# KITITAS COUNTY

### MEMORANDUM

TO: Jeff Watson, Community Development Services  
FROM: Christina Wollman, Planner II *CW*  
DATE: February 3, 2011  
SUBJECT: Kukes BL-11-00002

The Public Works Department has reviewed the Request for Boundary Line Adjustment Application. In order to ensure that it meets current Kittitas County Road Standards, the applicant needs to provide the following prior to final approval:

PROPOSED

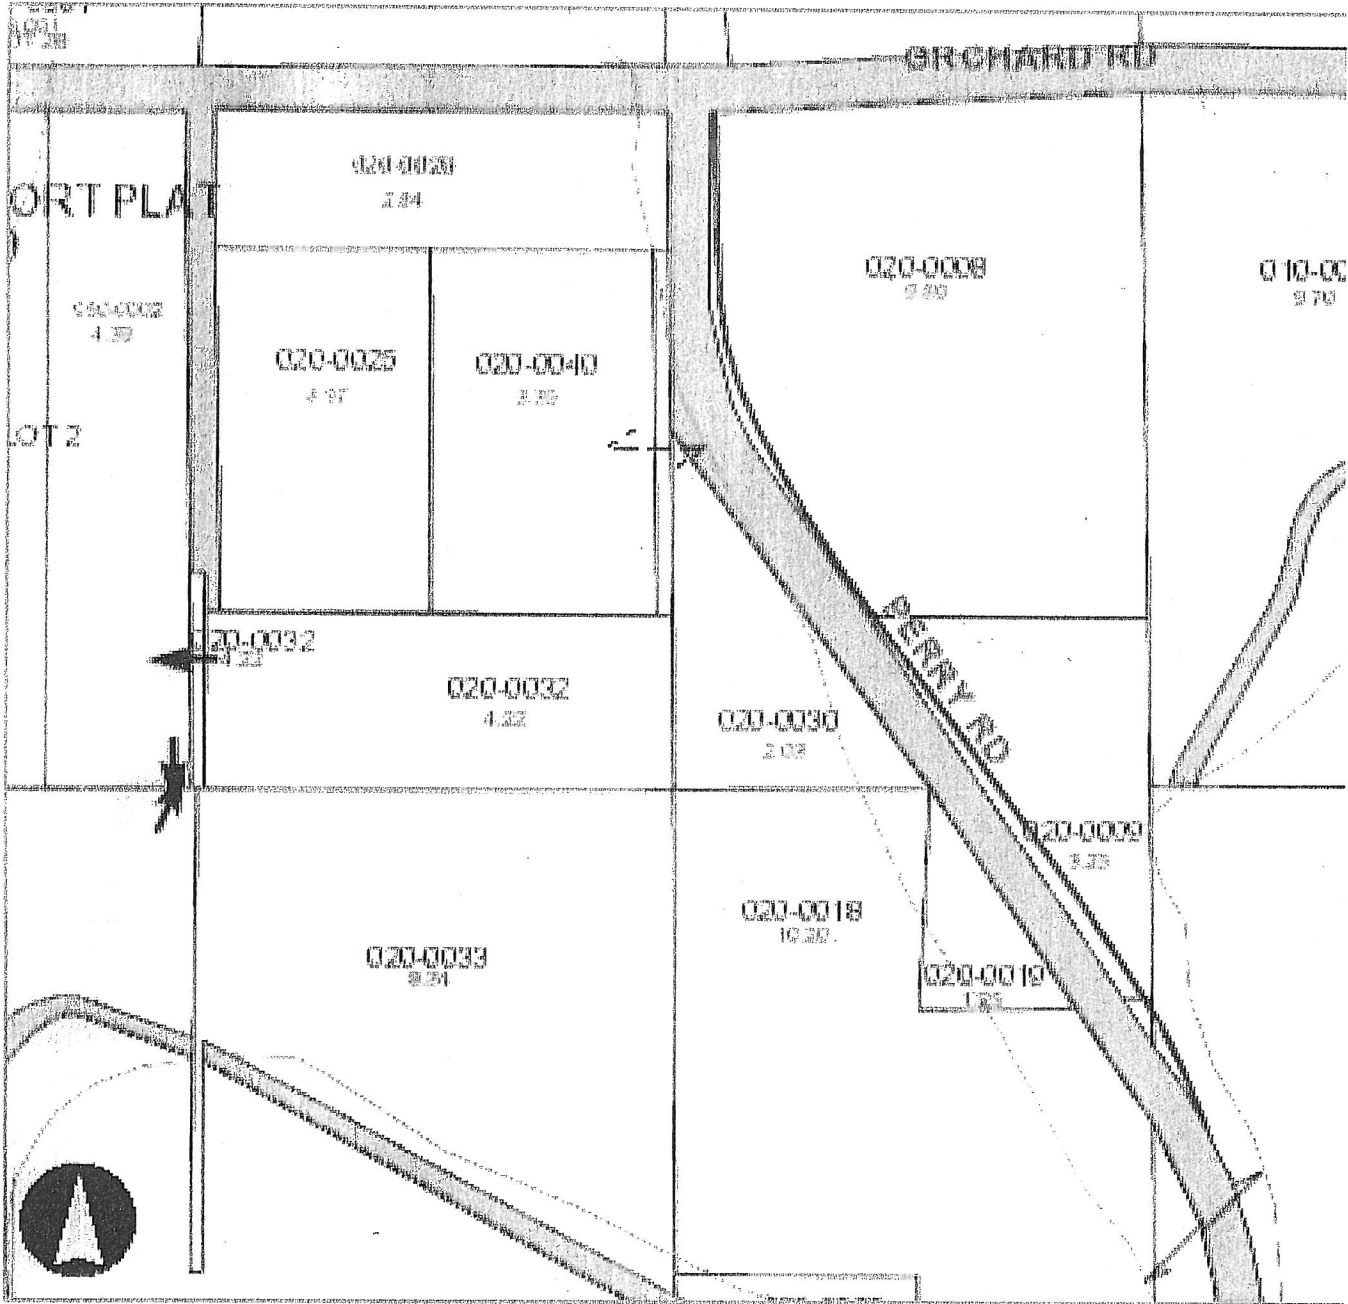
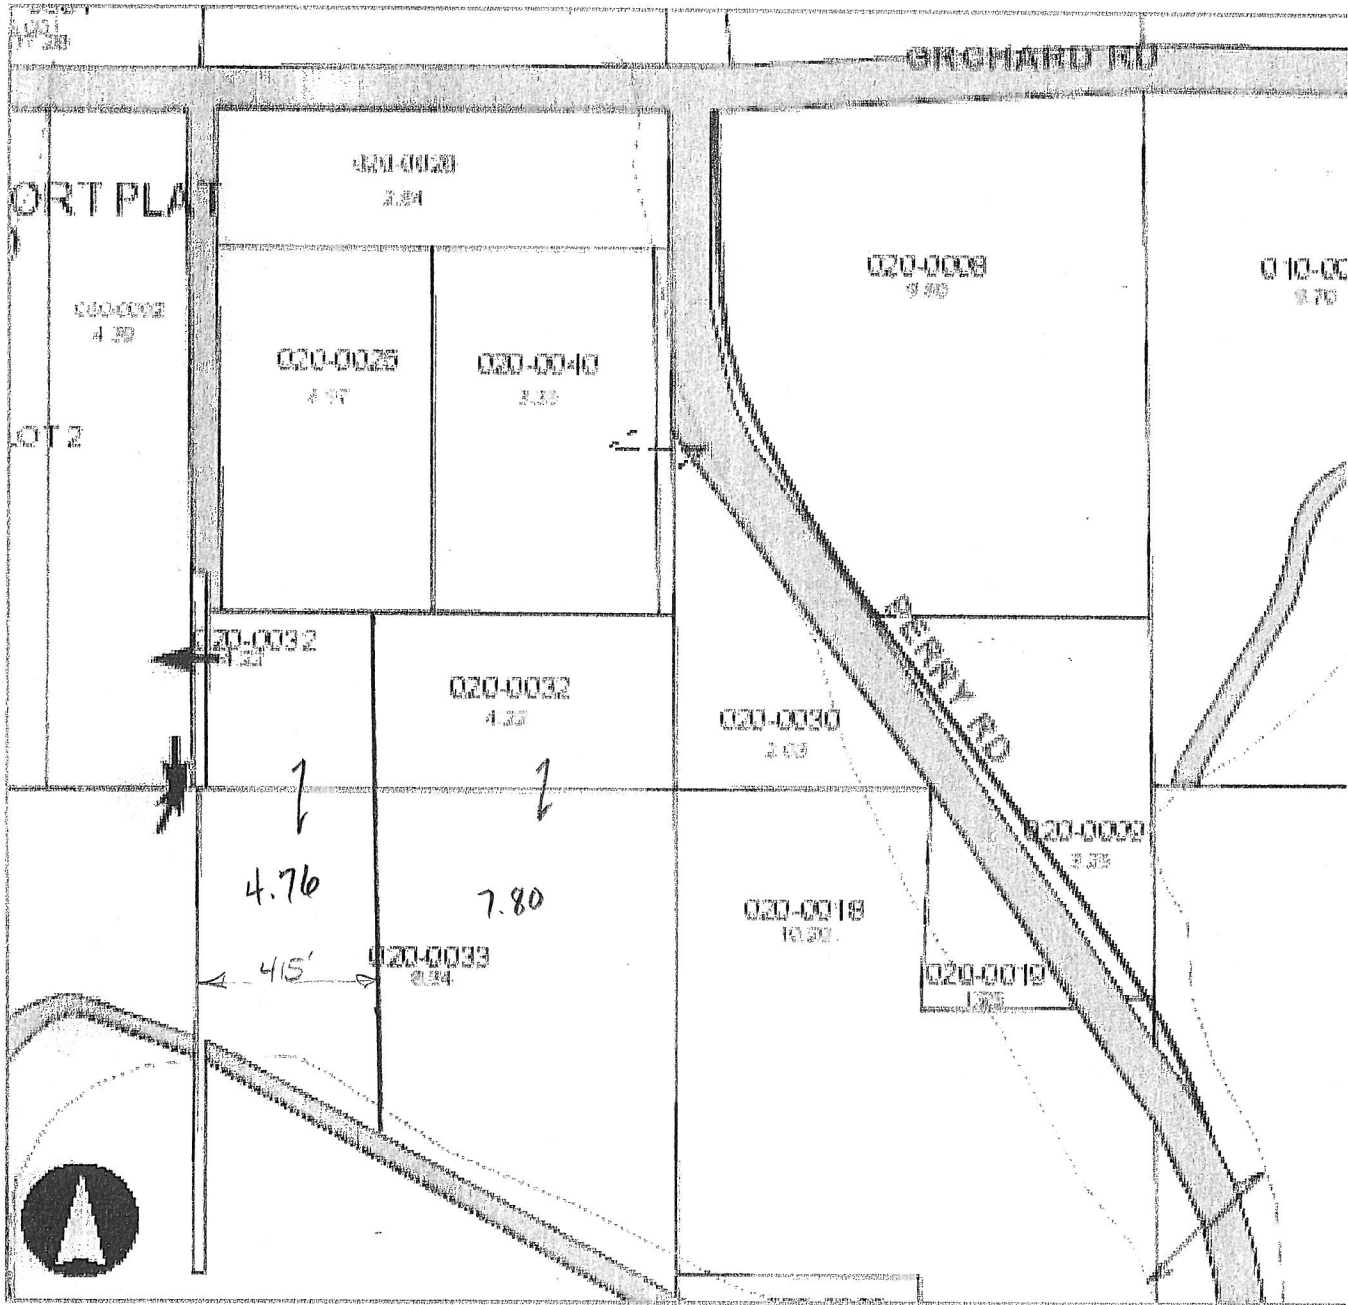
1. The proposed access with appropriate easement(s) shall be shown or described and shall conform to applicable Kittitas County Road Standards.
2. A revised legal description or survey that describes the final configuration of the subject property shall be required.
